**Re: Take 5 Oil Change at 2030 Gibson Blvd SE
Erosion and Sediment Control Plan
Engineer's Stamp Date – 1/14/26 - M15E021E – (SWQ-2026-00003)**

Based upon the information provided in your submittal received 1/14/2026, the above-referenced ESC Plan cannot be approved until the following comments are addressed.

DESIGN REVIEW COMMITTEE CITY ENGINEER APPROVAL ZONE MAP NO. M-15 & L-15
CITY PROJECT NO.
SHEET NO. **C3.1**
PAGE 2 OF 4

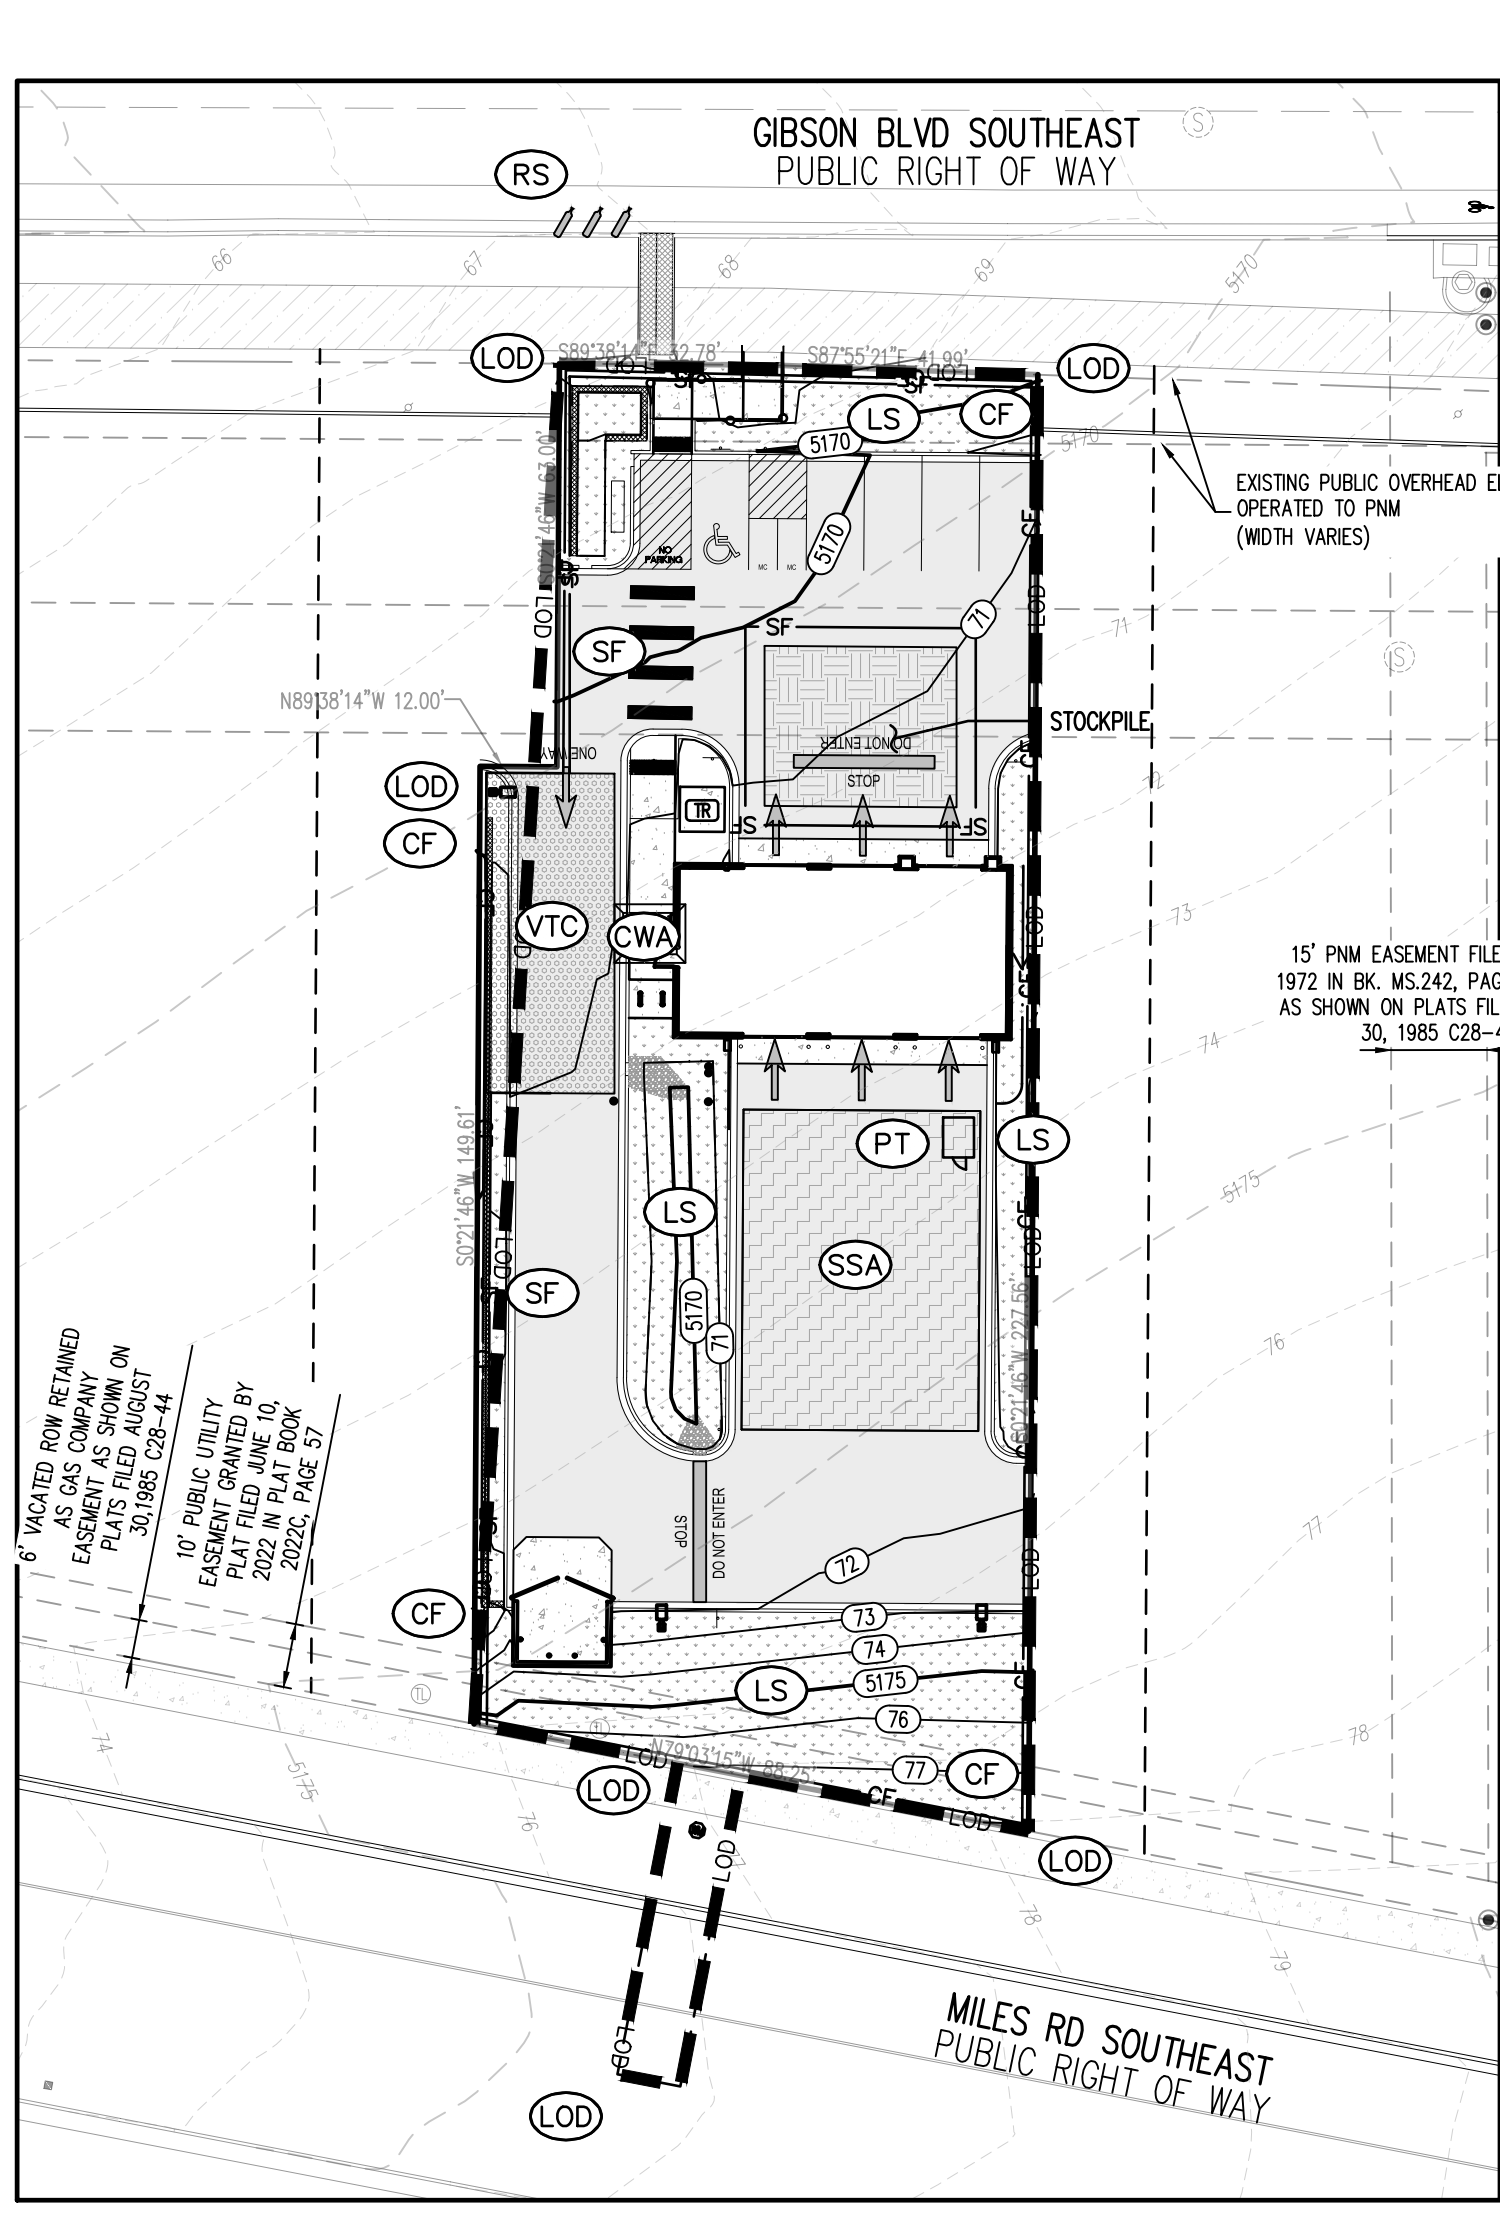
2. The notes on sheet C1.3 are in error where it says "Existing site runoff discharges through sidewalk culverts into Gibson Blvd." A second Discharge Point goes west into Lot B. Identify both Discharge points on the ESC Plan.

3. The notes on sheet C1.3 are further in error where it says, "Offsite flows don't enter the project site." The off-site areas were previously identified on sheet DR-1 of the approved G&D Plan. Correct the note and identify the off-site drainage areas and their discharge points into this property on a drainage area map as one of the sheets in this ESC Plan.

1. Soil Loss Model results added to Section 4 of the SWPPP Report and note added to C3.1.
2. Note revised.
3. Note revised.
4. Sediment Traps added to the plan and SWPPP report. applicable details added to plan set,
5. Diversion channels added to the plan set.
6. Offsite contours updated to reflect offsite work by others. Concentrated flow paths identified with callout and spot elevation.
7. Higher resolution plot used for detail clarity.
8. Soil information table added to Cover Sheet.
9. City standard notes added.
10. Specific interim and final BMPs identified on C3.1. Landscape plans included as a supplemental document to the submittal.
11. New stamp on planset.

LOVELACE HEIGHTS ADDITION CITY OF ALBUQUERQUE 2030 GIBSON BOULEVARD	
EROSION CONTROL DETAILS	
DESIGN REVIEW COMMITTEE	CITY ENGINEER APPROVAL
ZONE MAP NO. M-15 & L-15	
CITY PROJECT NO.	
SHEET NO. C3.2	
PAGE 3 OF 4

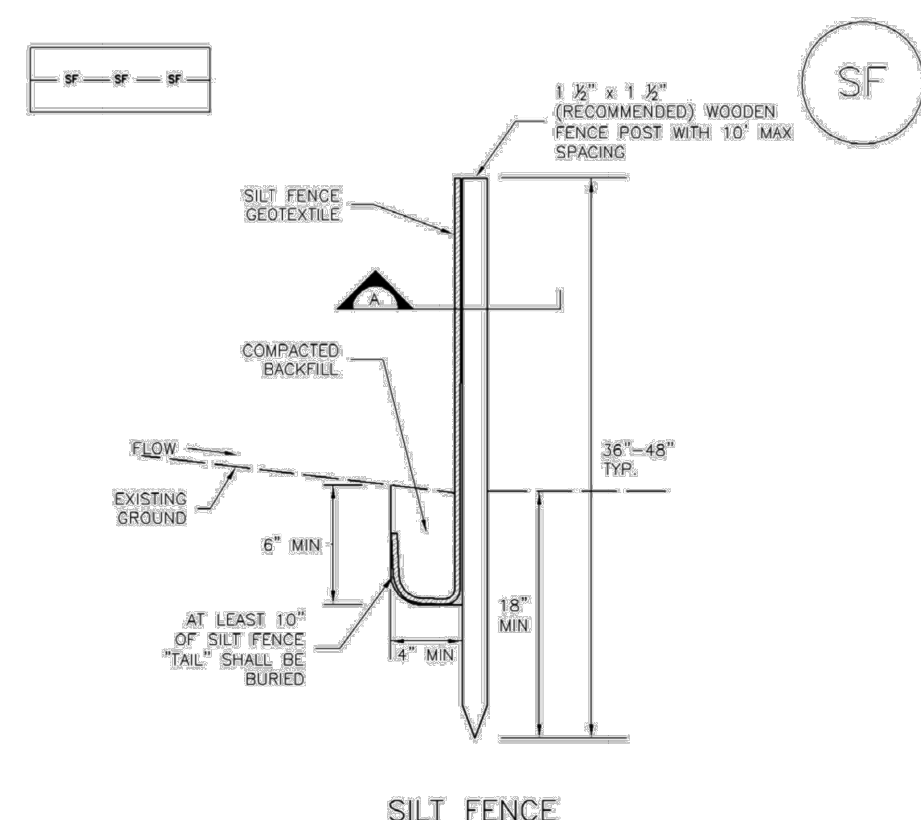
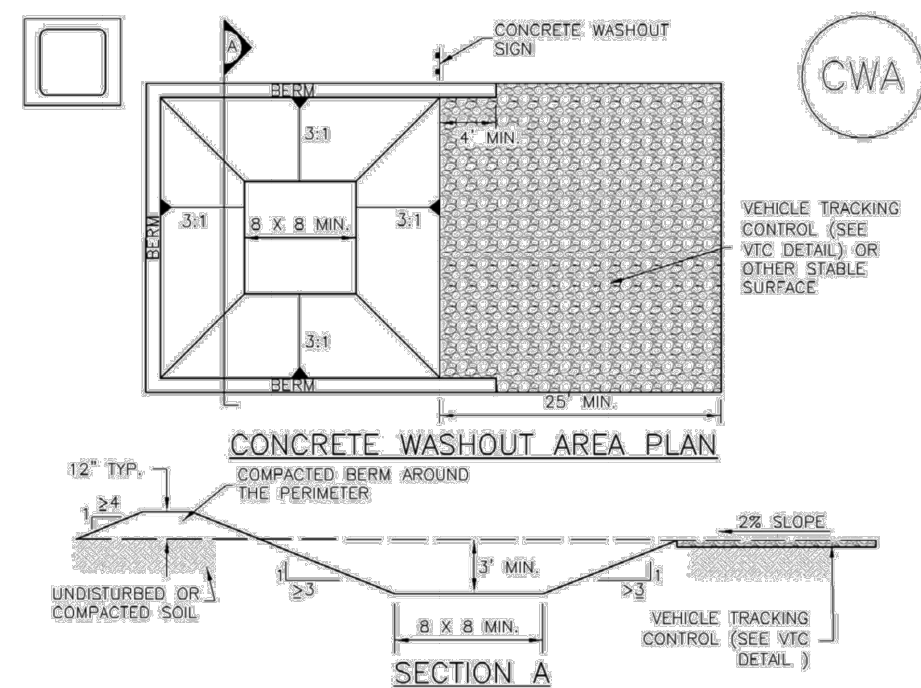
7. The text on the details sheets C3.2 and C3.3 is blurred and illegible.
8. Soil information – add a table with name type, particle sizes, and Erodibility factor (CGP 2.1.1).
